Recommendation Report for Planning Permission for Works or Extension to a Dwelling

REF NO: BR/183/19/HH

LOCATION: 37 Hillsboro Road
Bognor Regis
West Sussex
PO21 2DX

PROPOSAL: Single storey rear extension & bedroom in roof through the introduction of a dormer, following demolition of existing kitchen extension & conservatory.

NORTH-EAST ELEVATION AS PROPOSED

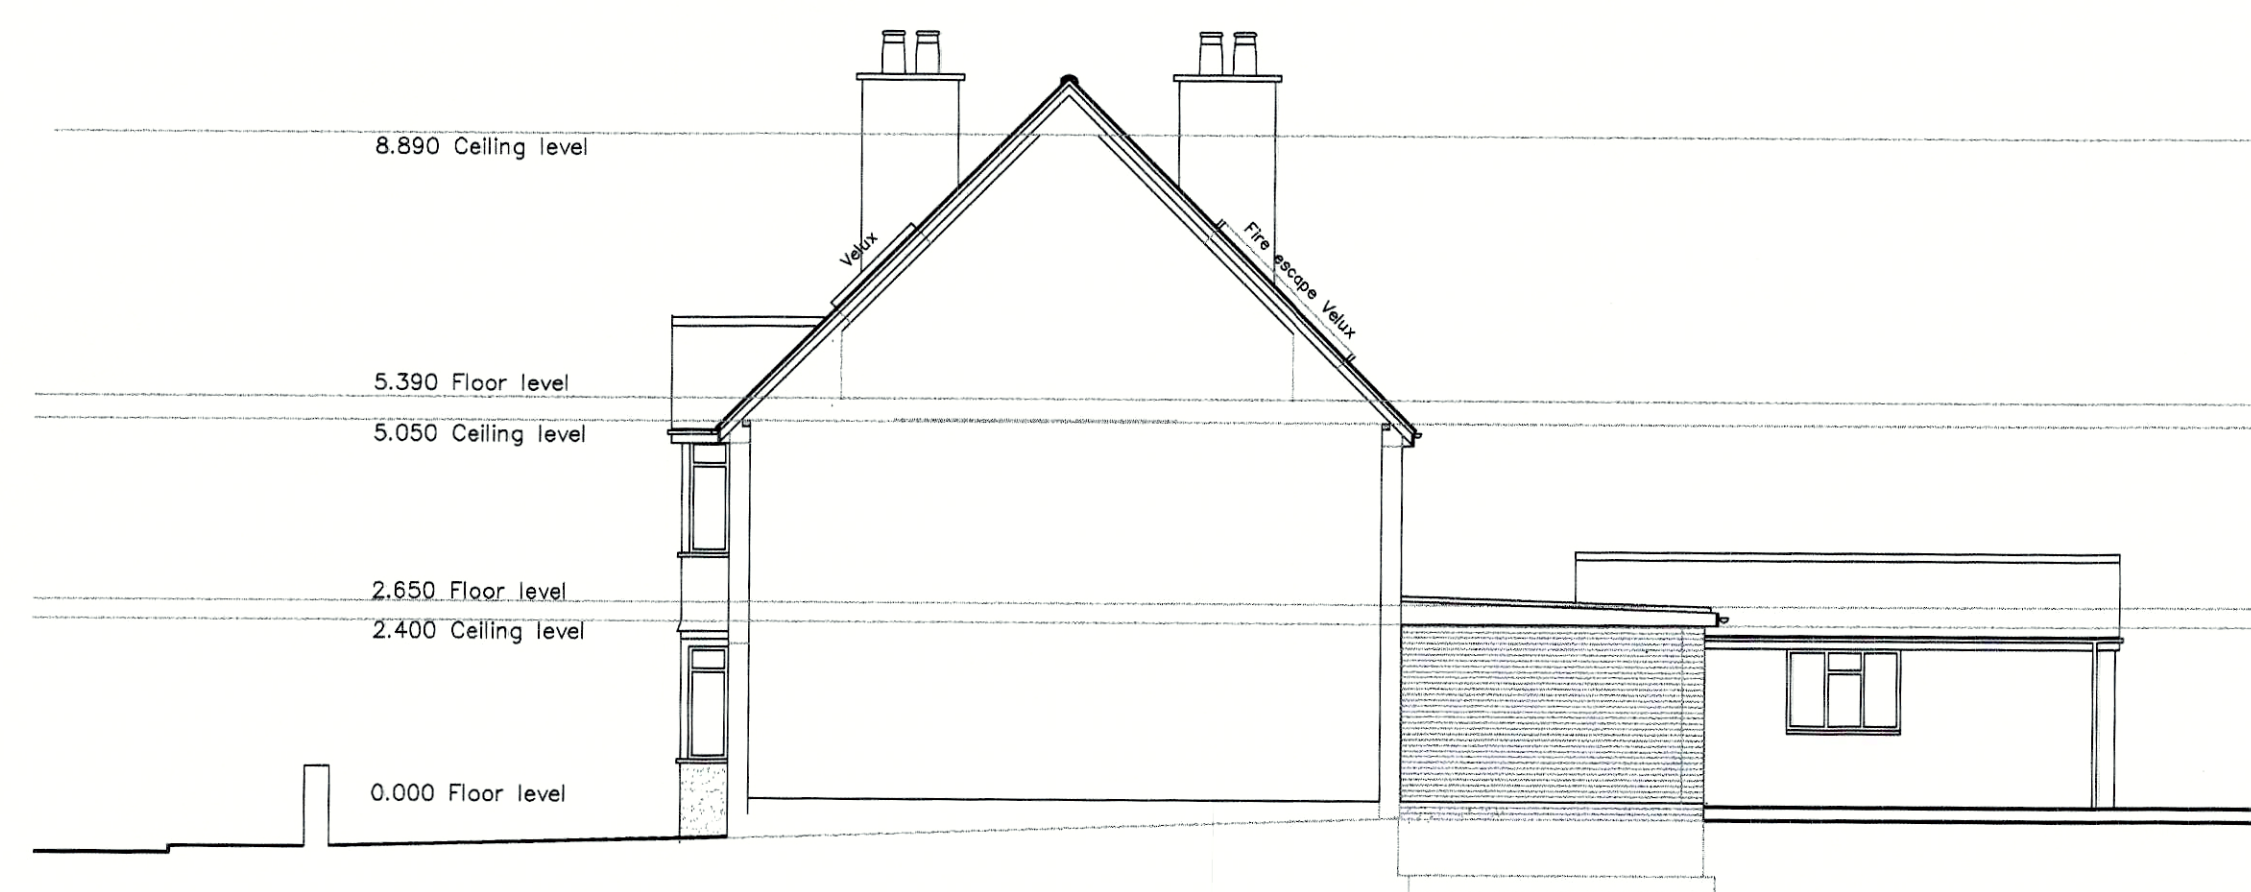
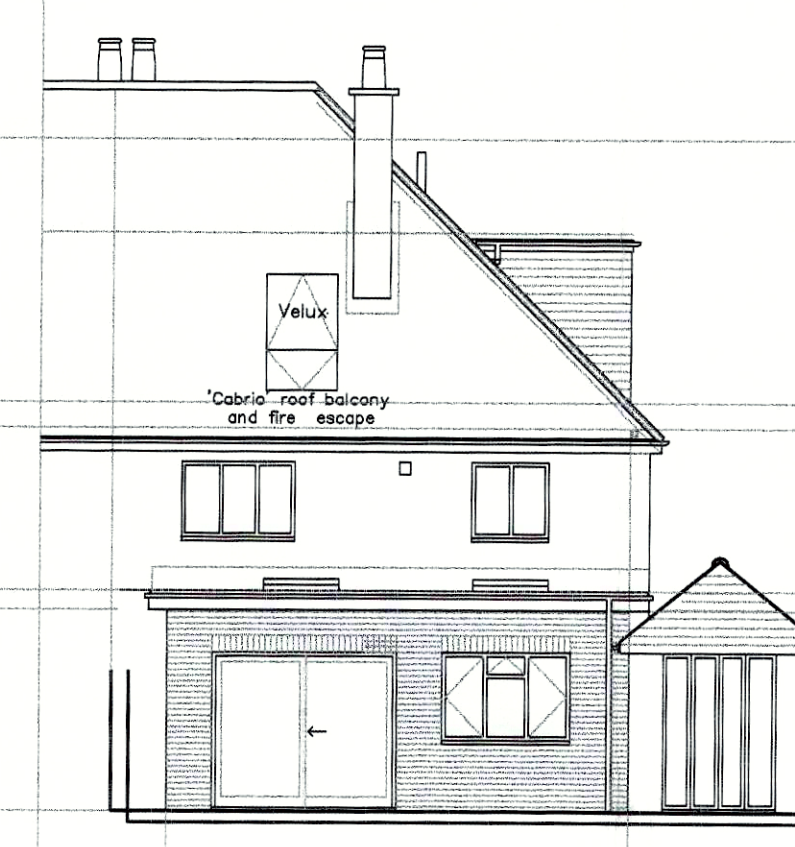
rise to some overlooking from the proposed window on the dormer to the North East, to overcome this the condition to ensure the window is obscure glazed has been added.

- 3 The window above first floor level in the on the North- East elevation of the building shall at all times be and remain glazed entirely with obscure glass.

GROUND FLOOR PLAN AS PROPOSED

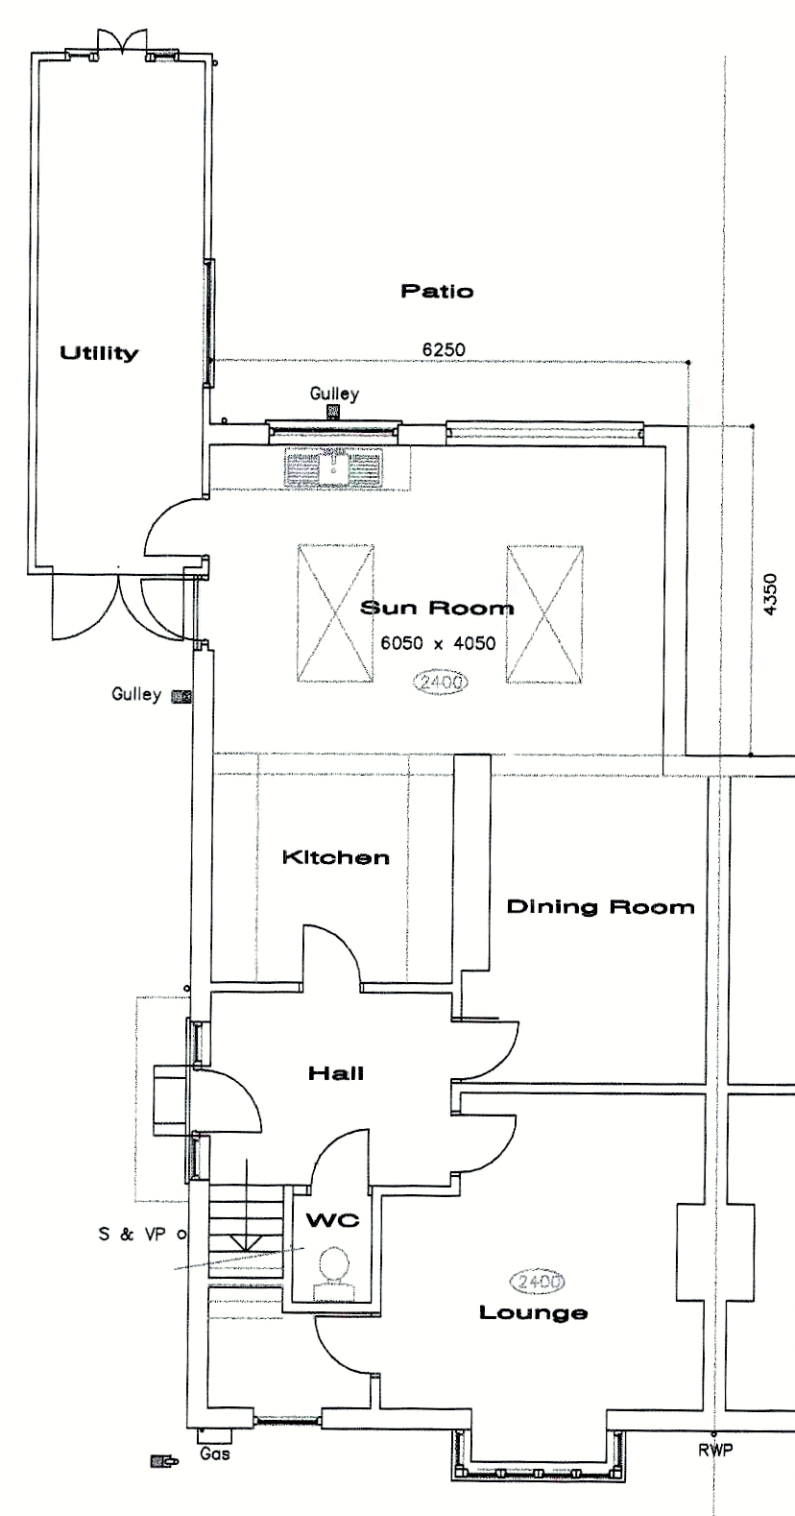
The applicant seeks planning permission for the construction of a rear extension to the established dwelling. The proposed rear extension will measure approximately 6.25m wide, 4.35m in depth and be built to the proposed height at top of lean to of 2.65m and eaves measuring 2.4m.

The proposed rear extension will be located 18m from the eastern boundary, 2.5m from the northern boundary and 0.2m from the southern boundary. On the rear (south east) elevation there a pair of proposed sliding doors and a window. On the side elevation there are 1 No. proposed door this will be to grant easier access to the utility room. There will be a second side door to the extension.
